EPBC Ref: 2012/6378

Comment on proposed modification (Mod 1) to Bengalla Mine Continuation Project (NSW reference: SSD-5170 Mod 1)

Figure 1.1. Conceptual layout of the Modification

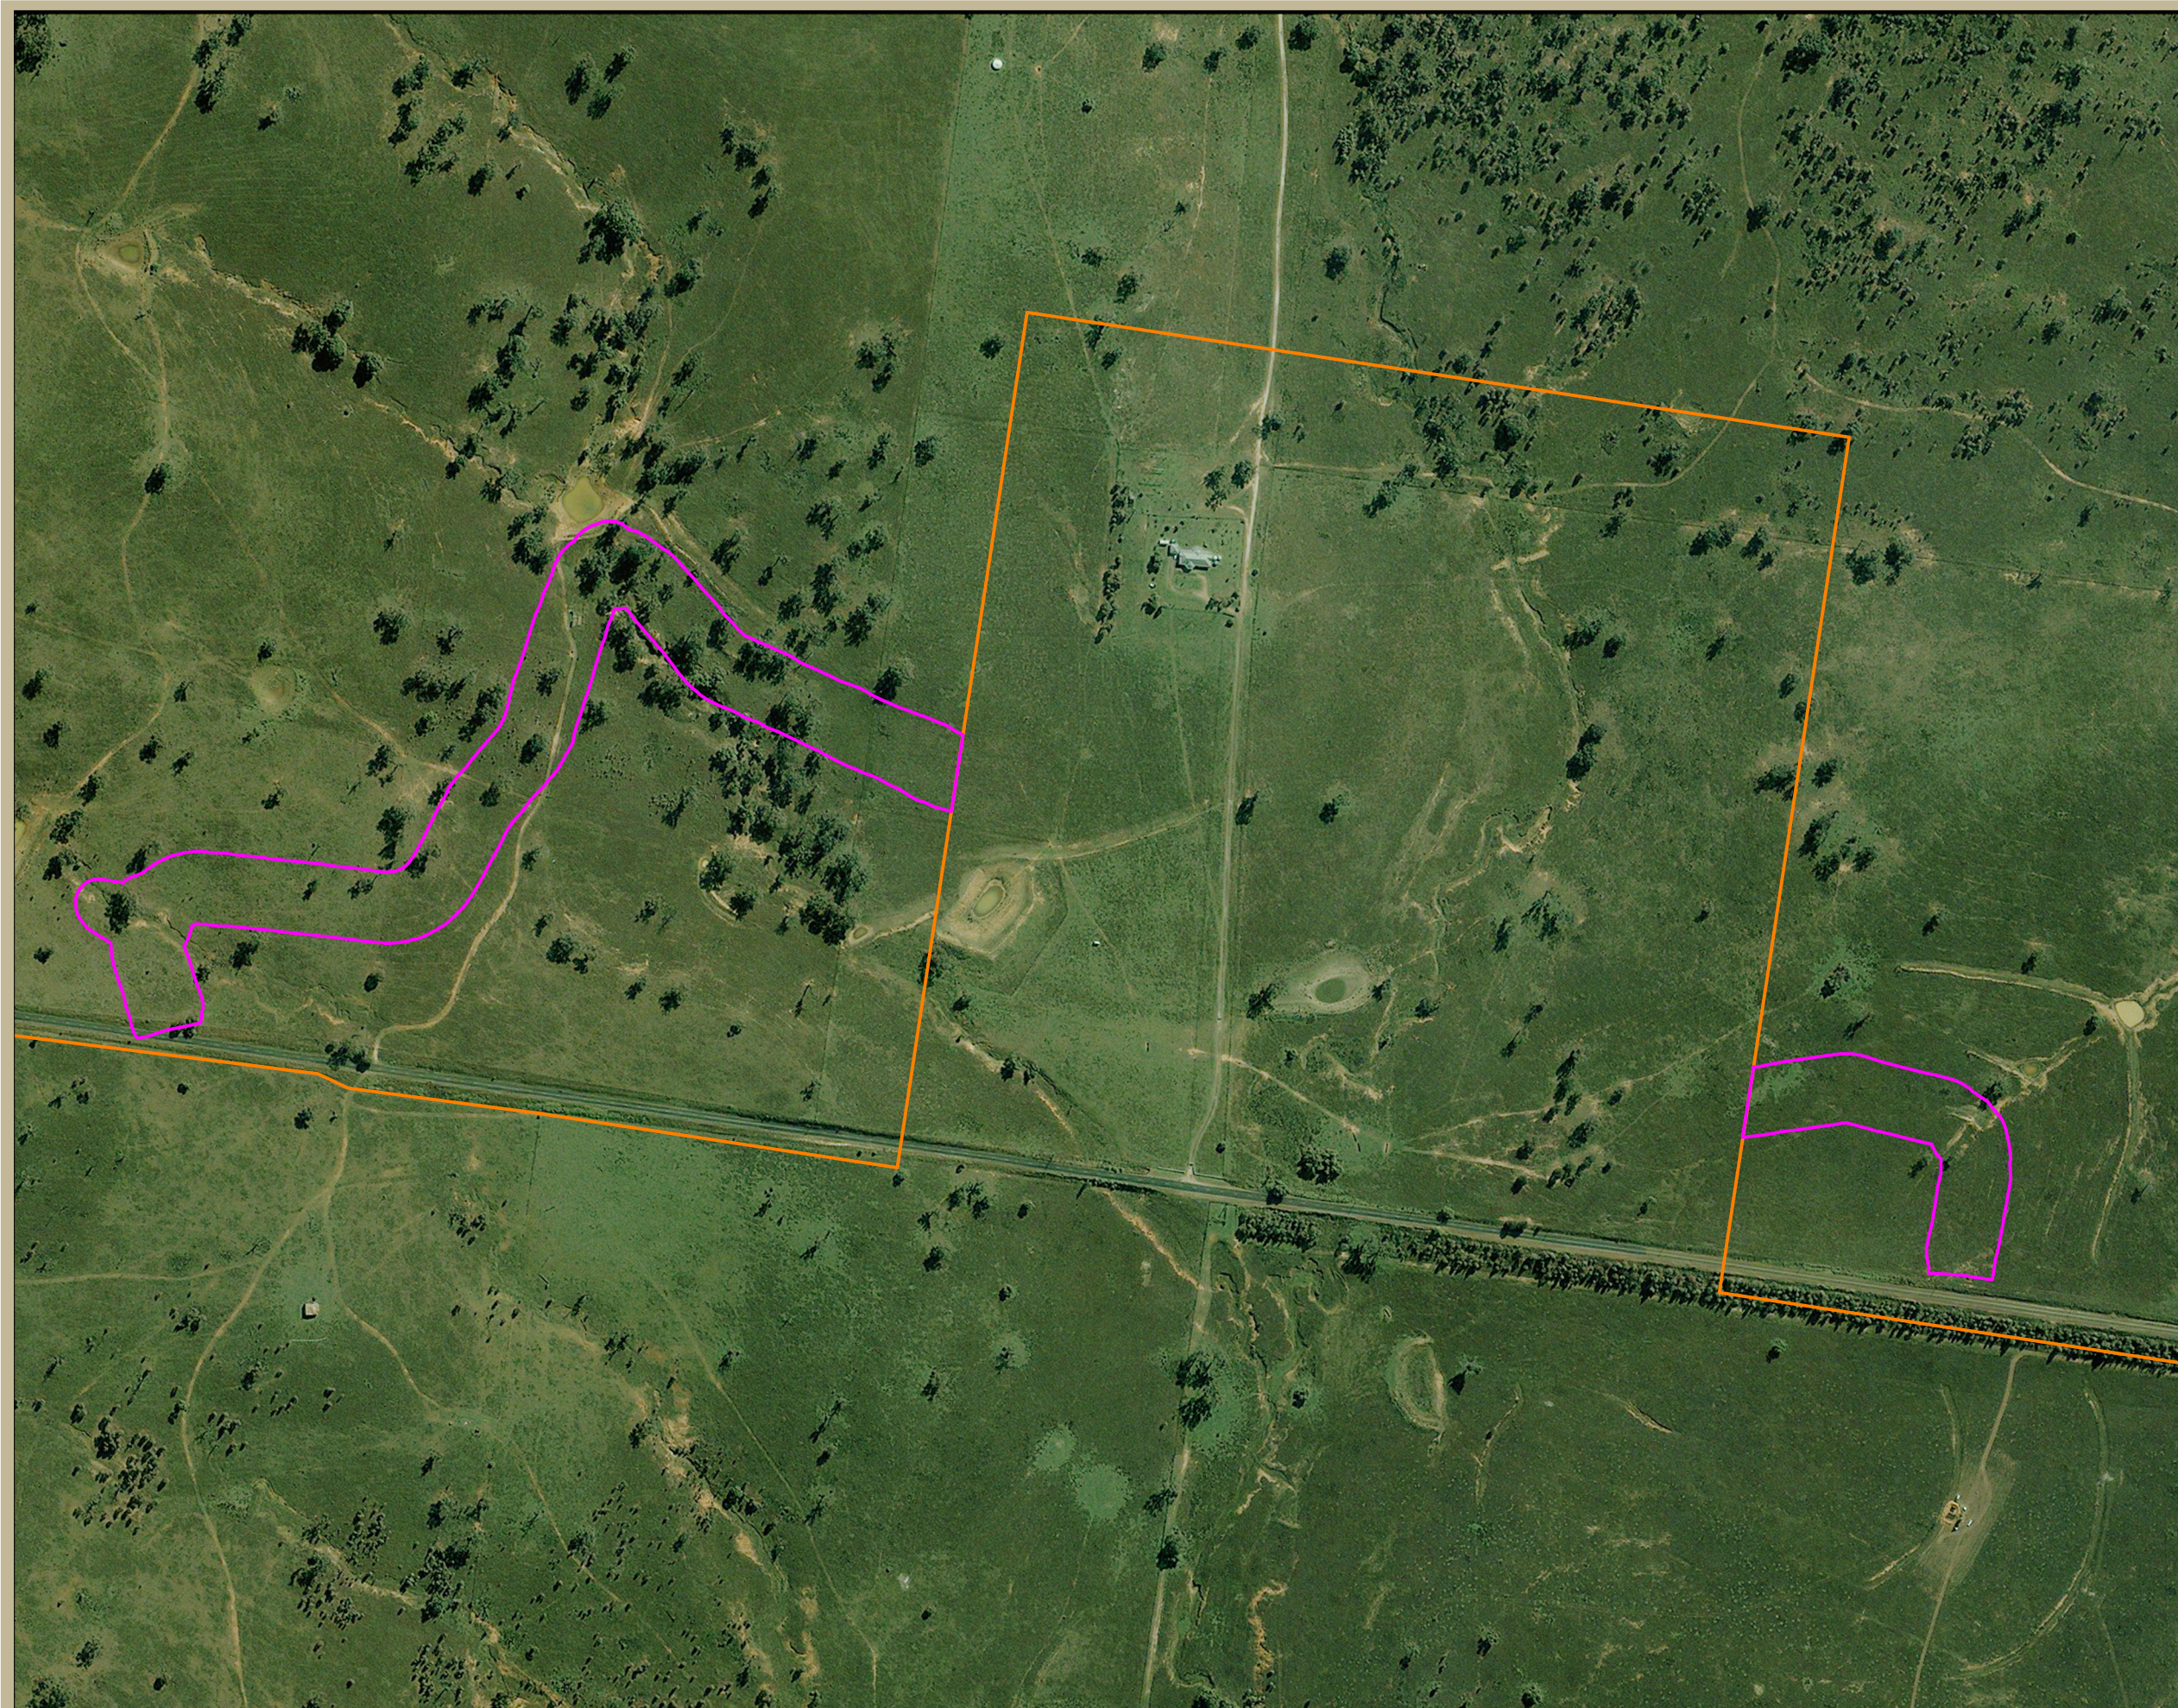
- Implementation of the modification may result in inconsistencies with the EPBC approval 2012/6378 (EPBC approval) as follows:
 - Removal of vegetation beyond the clearance boundary defined in Condition 1 and Schedule 1

Figure 3.1. Vegetation communities within the Modification to Disturbance Boundary

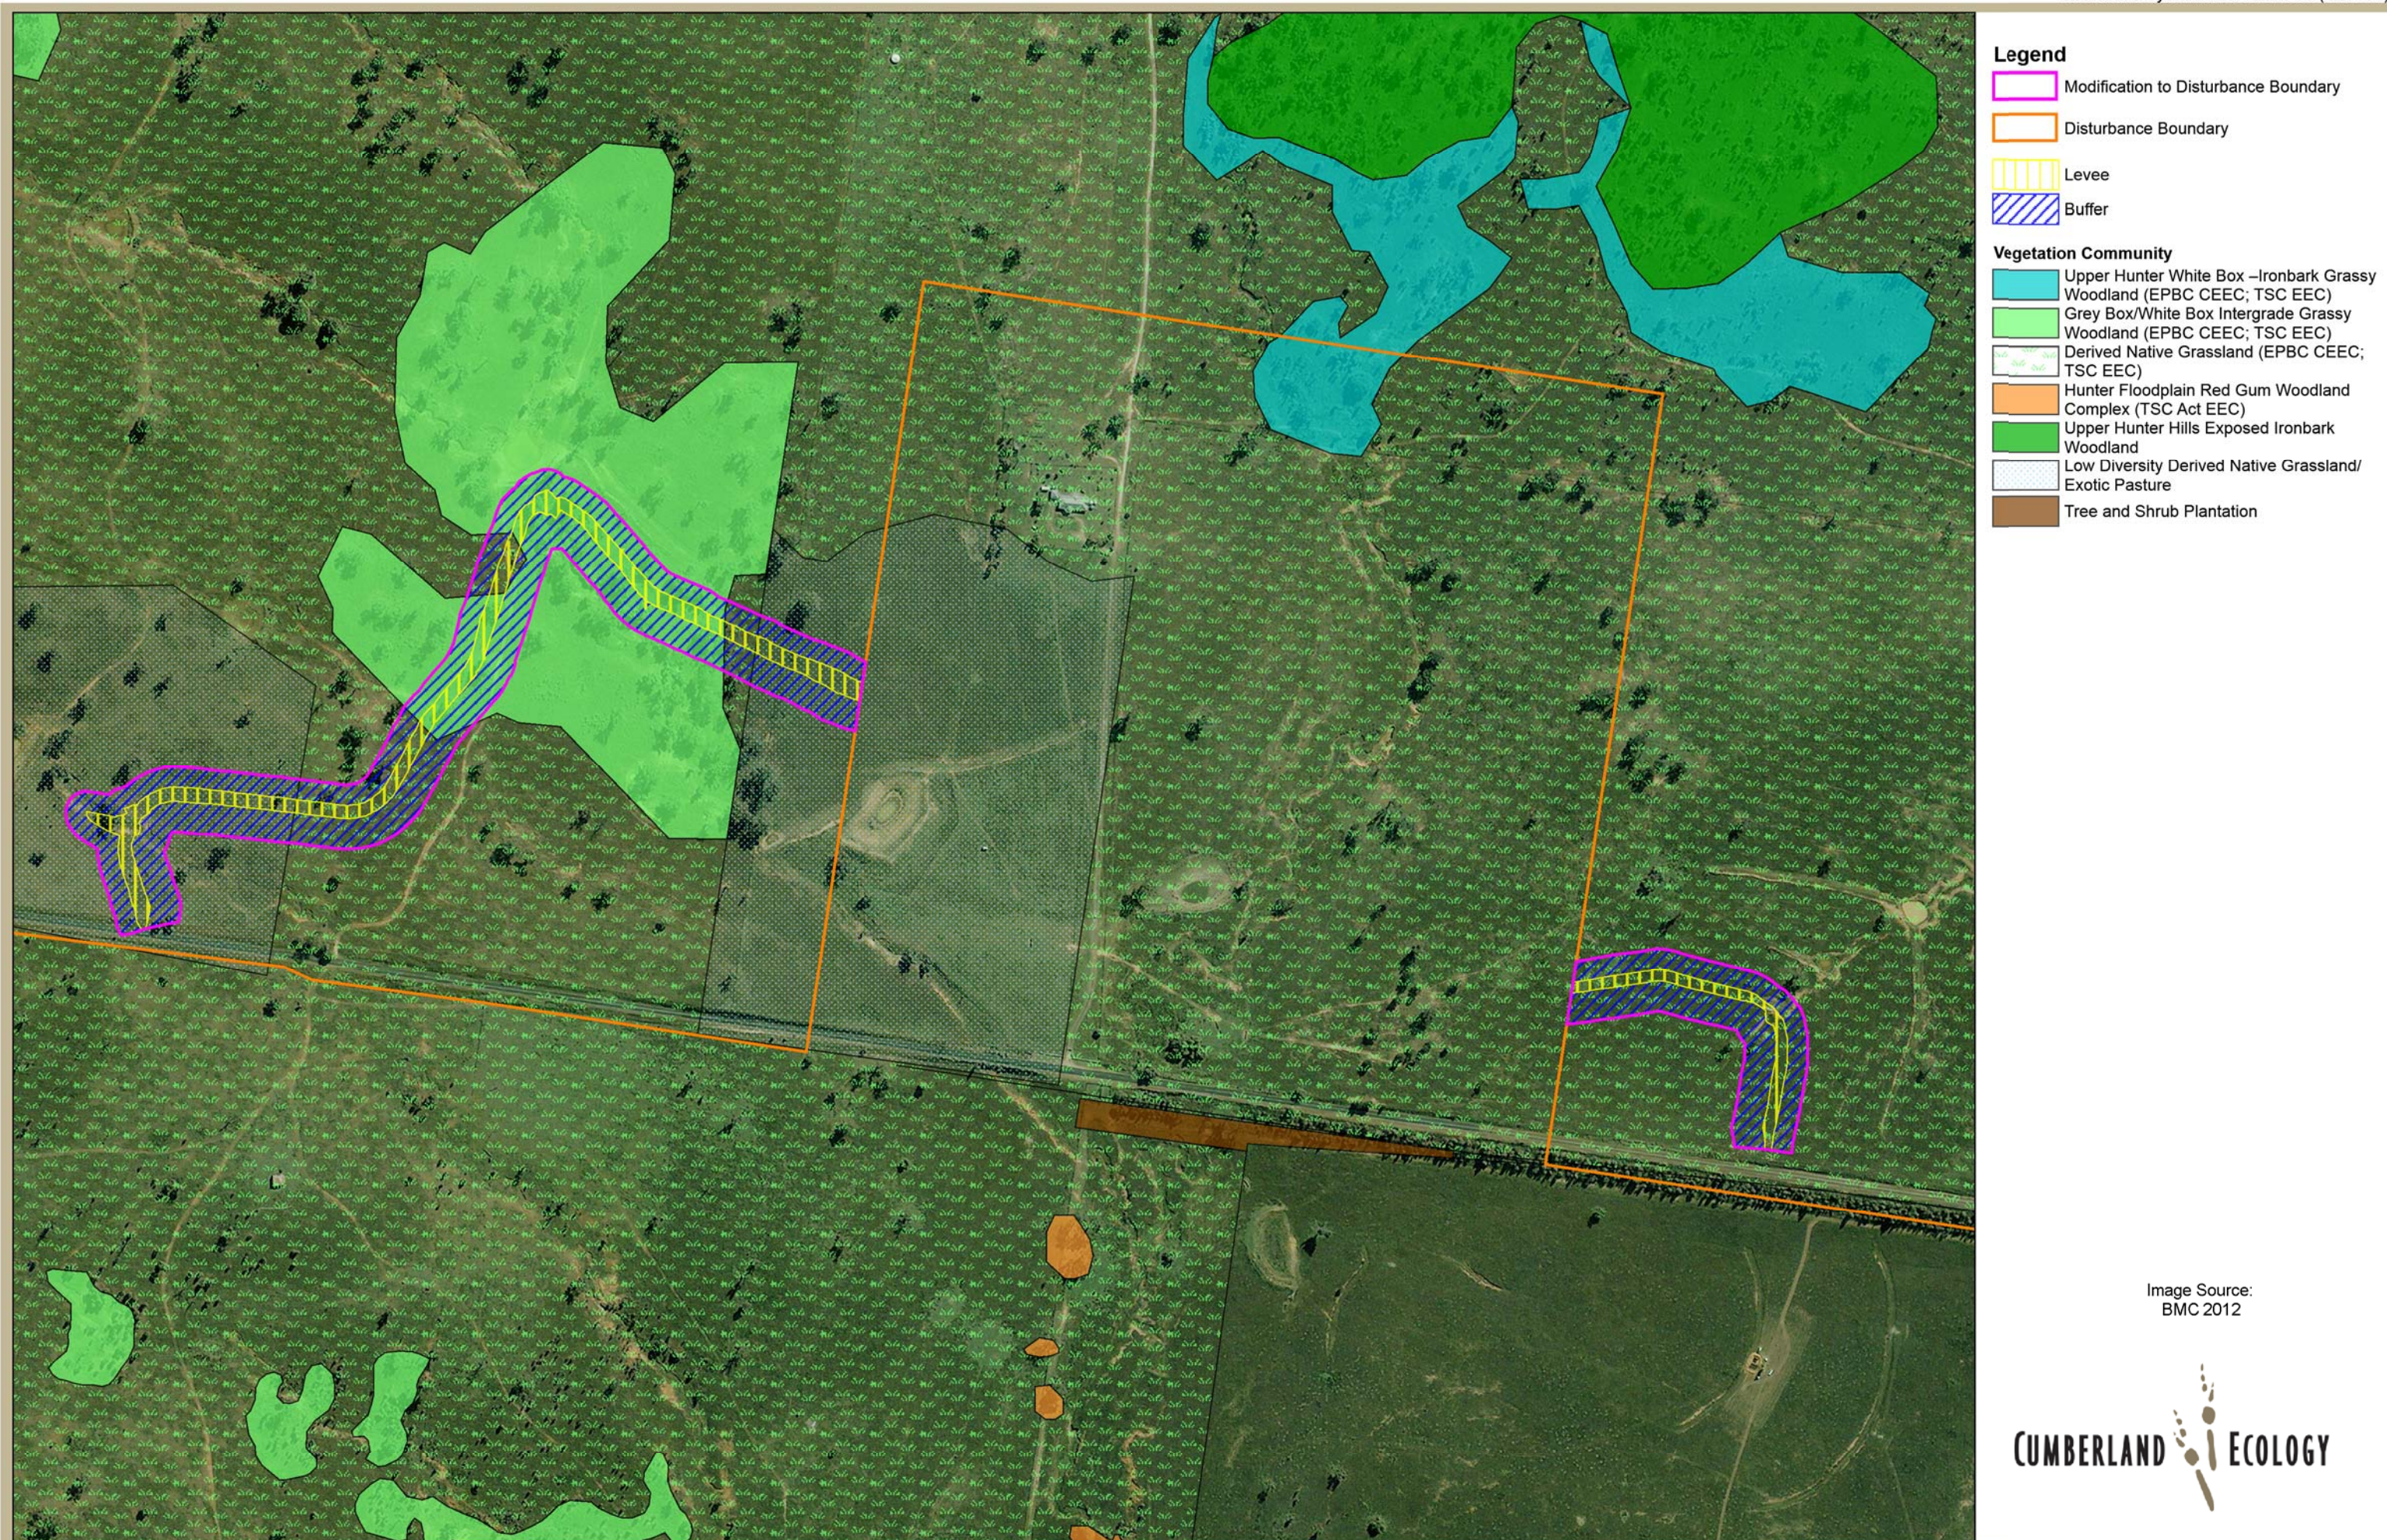
- Clearance of 6 hectares (ha) of critically endangered *White Box-Yellow Box-Blakely's Red Gum Grassy Woodland and Derived Native Grassland* (Box Gum Woodland) and habitat for EPBC-listed species, if this causes the clearing limits specified in Conditions 1 and 3 to be exceeded
